12255
8 June 2017

**SECTION 96(2) MODIFICATION APPLICATION SSD 7388 – MOD 3
31 WHEAT ROAD, SYDNEY**

On behalf of Grocon (Darling Harbour) Developments Pty Ltd we hereby submit an application pursuant to section 96(2) of the *Environmental Planning and Assessment Act, 1979* (EP&A Act) to modify SSD 7388 relating to The Ribbon development (former IMAX site).

SCALE @ B1	DRAWN	CO-ORD	REVIEWED	APPROVED
NTS	RT	MH	MH	EL
PROJECT NUMBER	DRAWING NUMBER	REV		
A004409	ARC-HSL-DD-SK-525.1	A

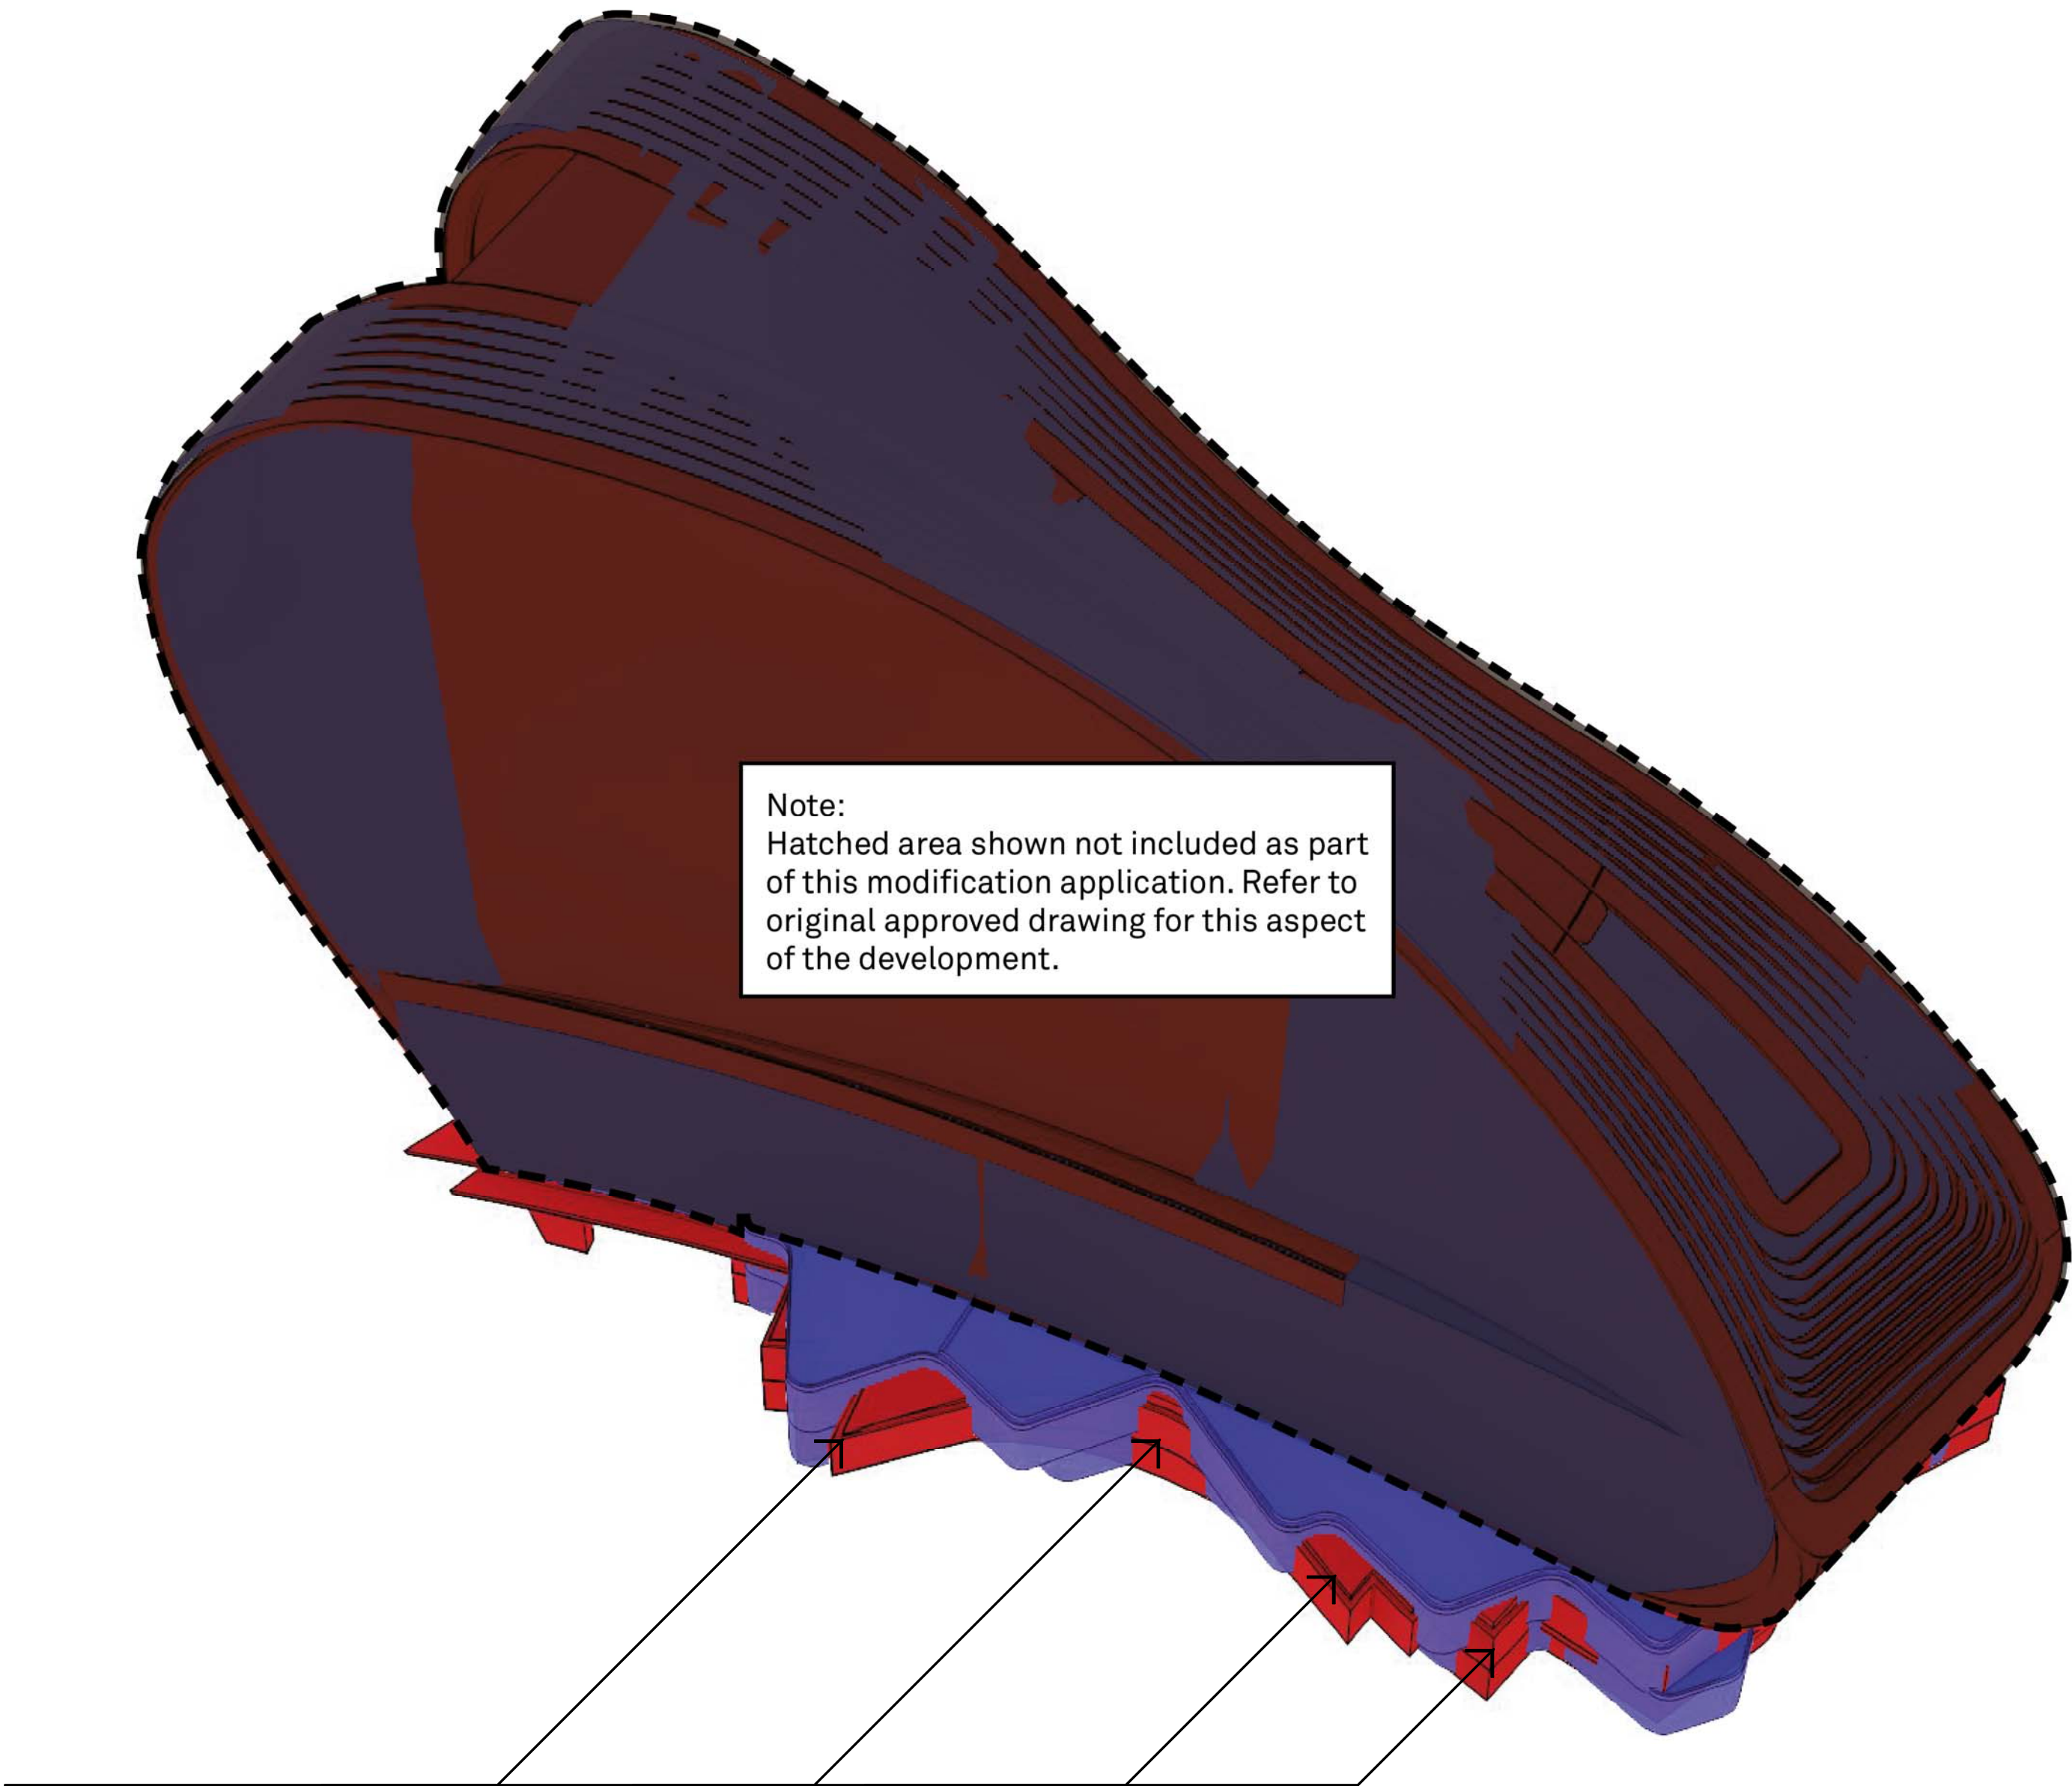
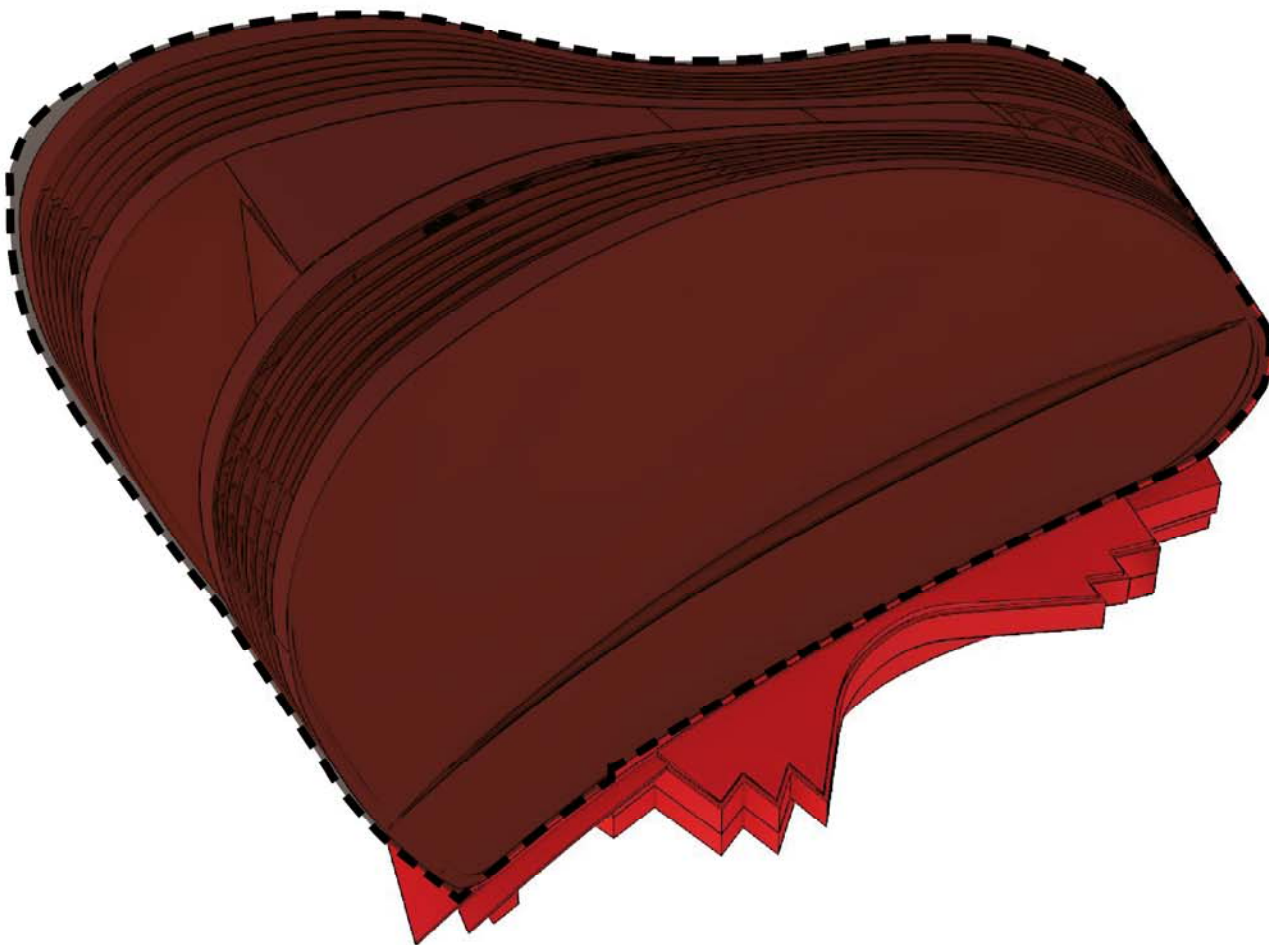
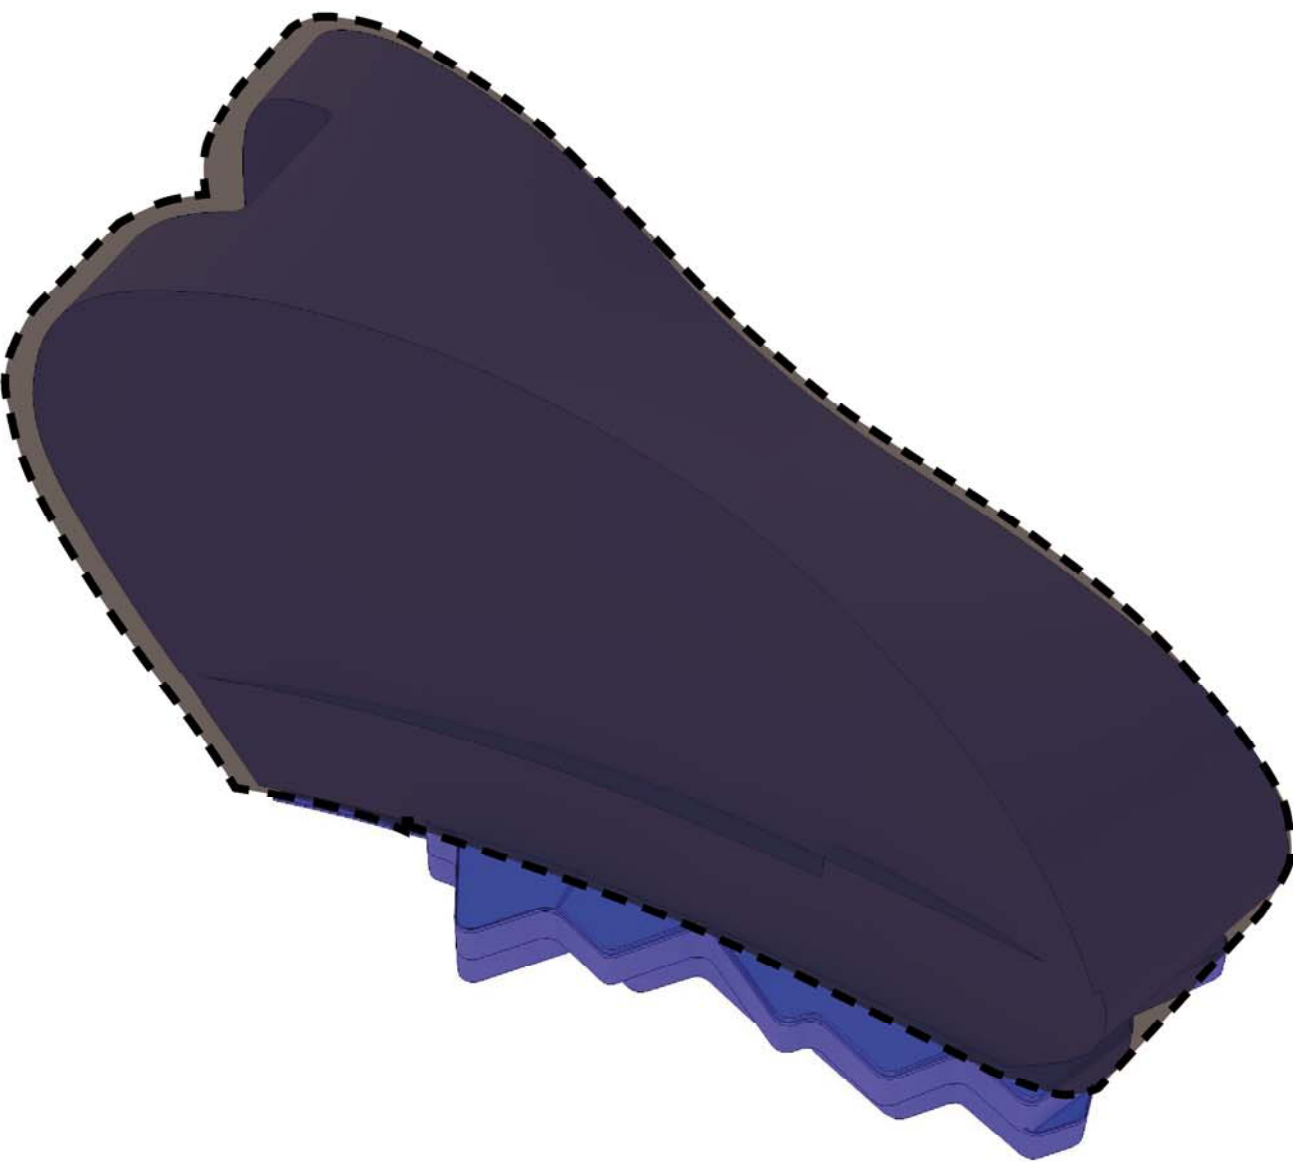
2.1 Refined podium envelope

Hassell has reviewed the design of the podium envelope to better align the geometry of the tower with the podium. The DA concept may be interpreted as a vertically curling ribbon (tower) resting upon a horizontally undulating ribbon (podium), the proposed developed concept strengthens and reinforces this idea further by aligning the geometry of the tower and podium. In this way, the composition may be read as a series of sweeping, dynamic curves that re-interpret the lines of the western distributor overpasses into a shape that simultaneously creates a strong focus at its centre (the hotel main lobby and atrium) while reaching out towards the public domain and Darling Harbour beyond. The nested, projecting curves of the podium form also cleverly negotiate the complex offsets from the RMS overpass structure, optimising the interior floor area and rationalising the shapes of the rooms and improving their visual connectivity to the harbour.

Figure 3 provides a comparison of the approved and proposed podium footprint. As can be seen in the image the revised design generally occupies the same area as that originally approved. It also maintains the important sightlines that were identified in the assessment of the original proposal as demonstrated in **Figure 4**.

SK-530 EASTERN PEDESTRIAN CLEAR WIDTHS

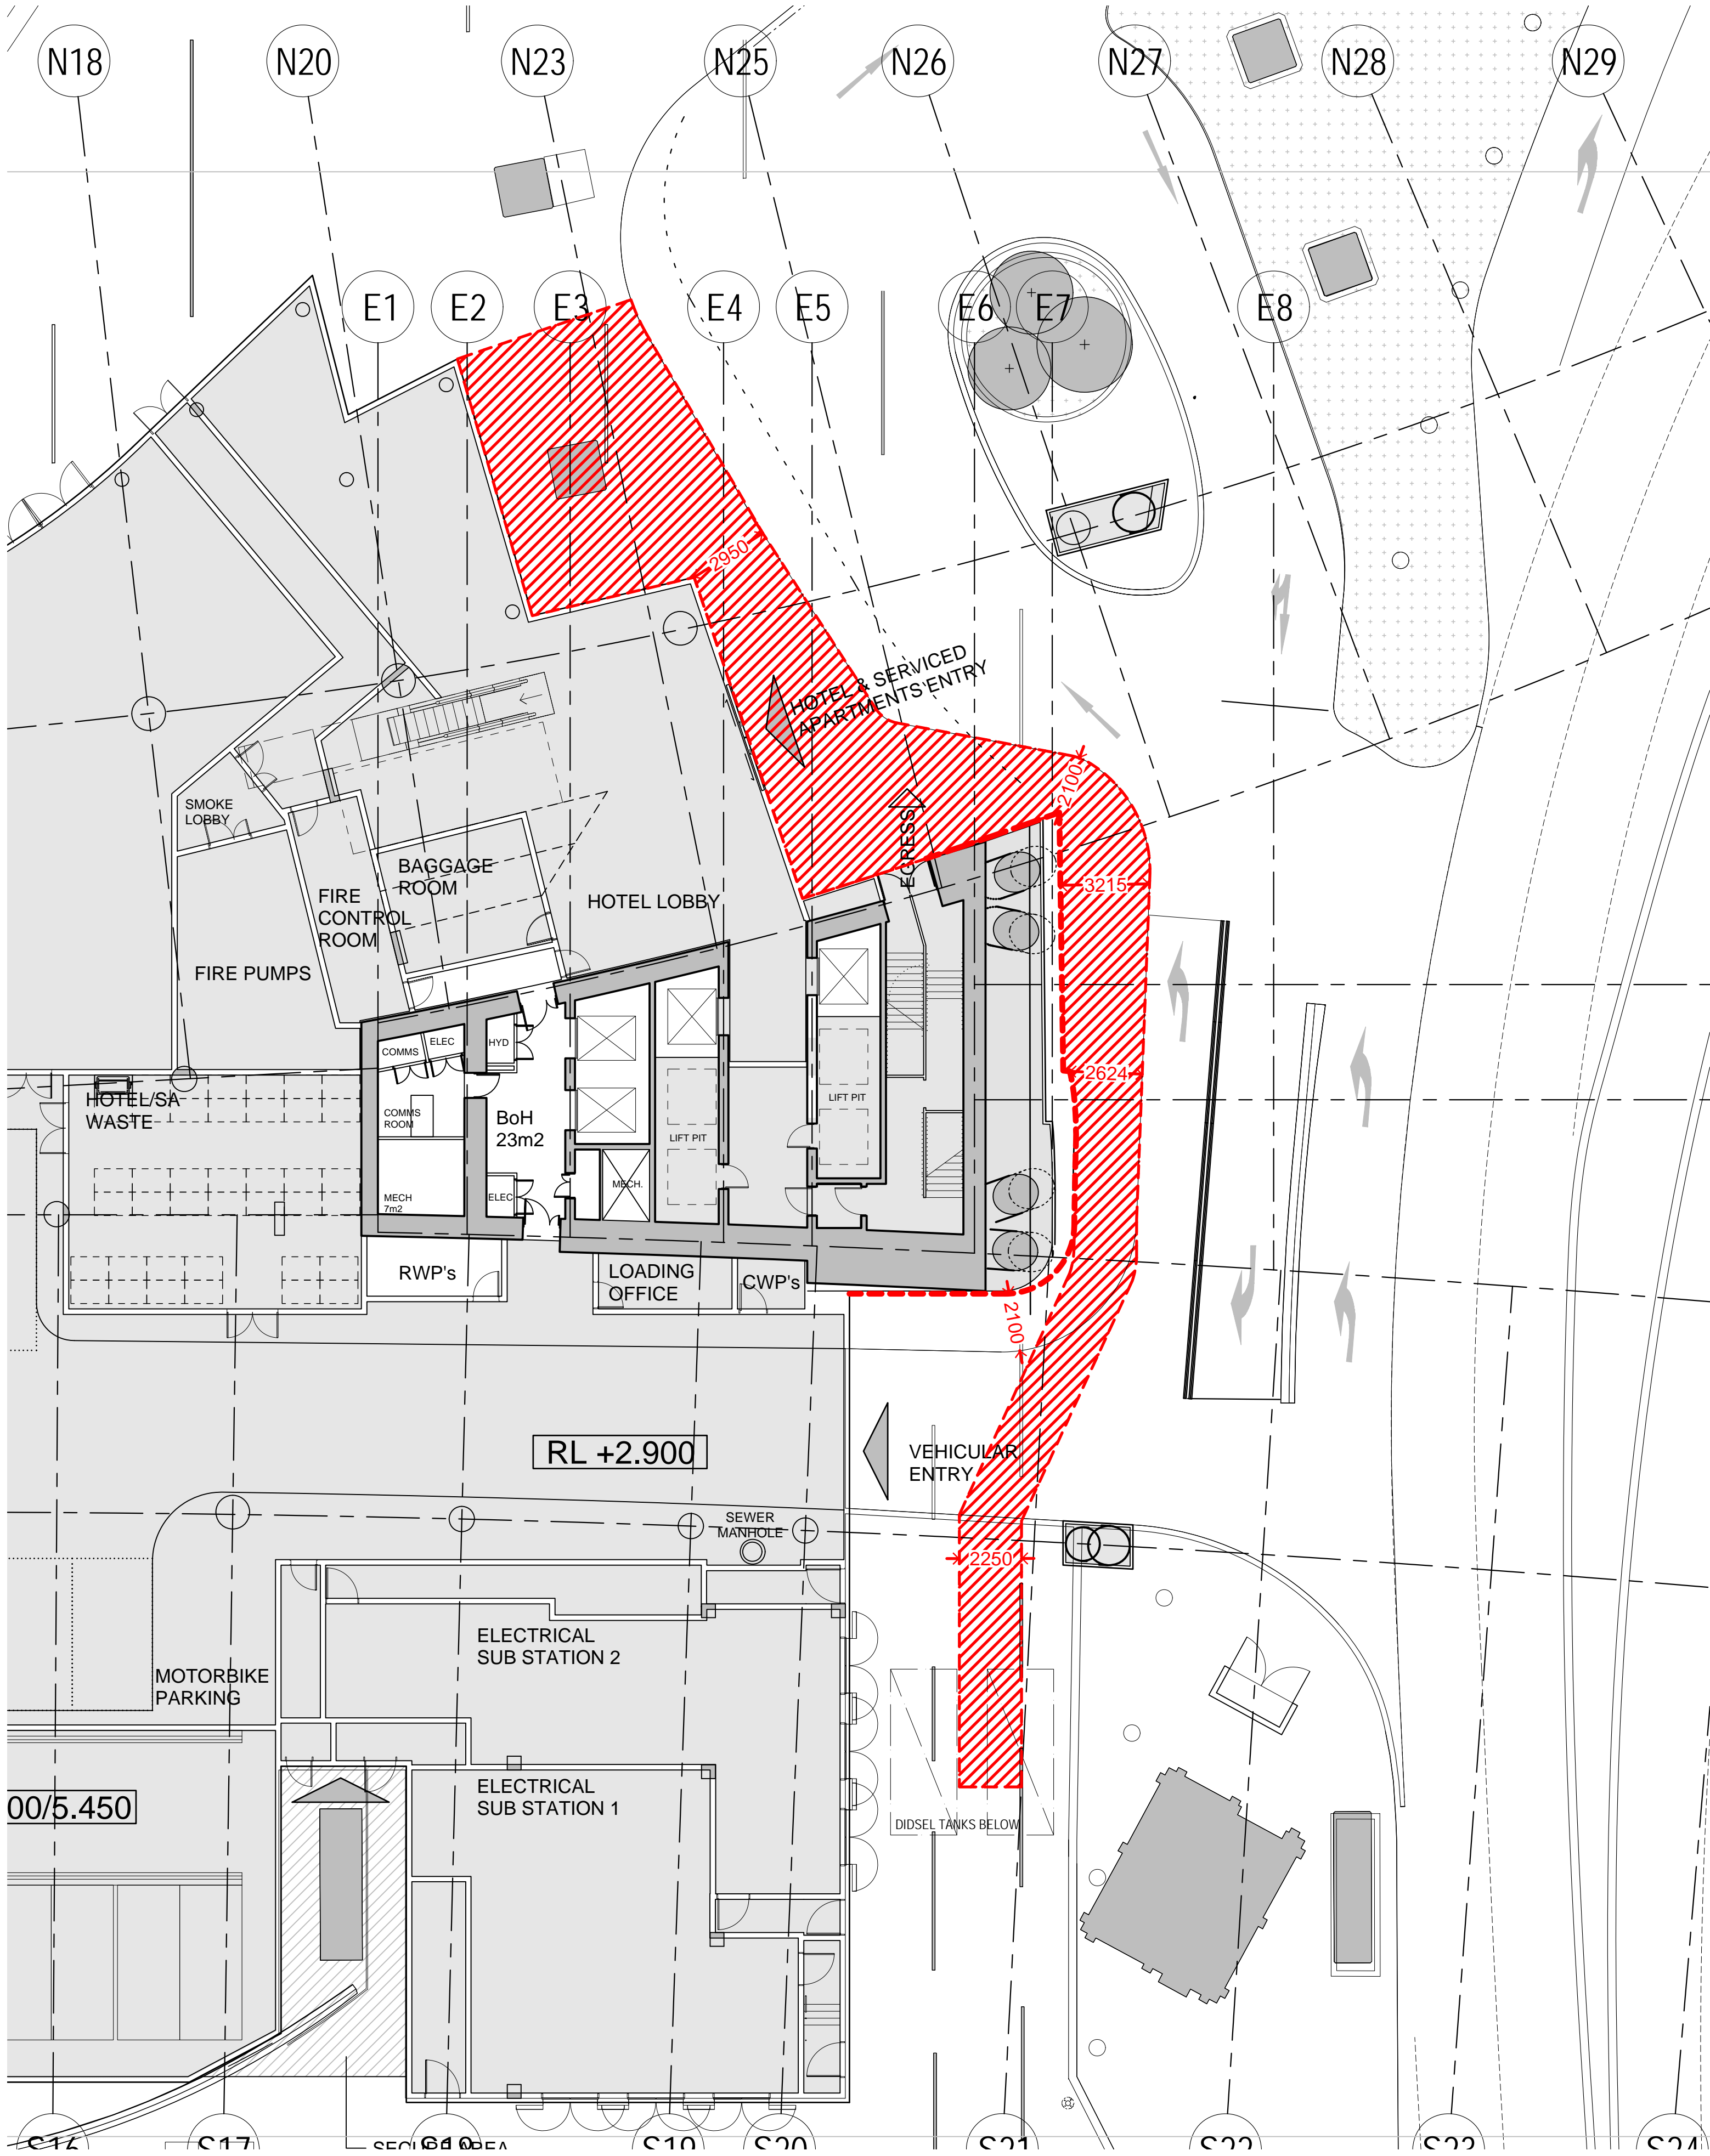
- B3** Prior to the issue of a Construction Certificate for Stage 2, amended plans and documentation are required to be submitted to the Secretary for approval, showing:
- (a) A footpath width of 4.5 metres where achievable and variable width, as indicated on drawing ~~SK-0235.1, dated 28 June 2016~~ **SK-530 dated 4 May 2017**, along the eastern frontage to the main building to provide adequate pedestrian circulation;
 - (b) ...

The proposal does have an impact on the width of the pedestrian paths along the eastern edge of the podium. Following technical design development the structural columns now terminate to the core base and have increased in size. In order to improve the aesthetics of this element of the building, Hassell is now proposing to enclose the structure within the building envelope. Whilst it is recognised that such dimensions fall short of the desired width of 4.5m, they do exceed those specified as part of the approved development.
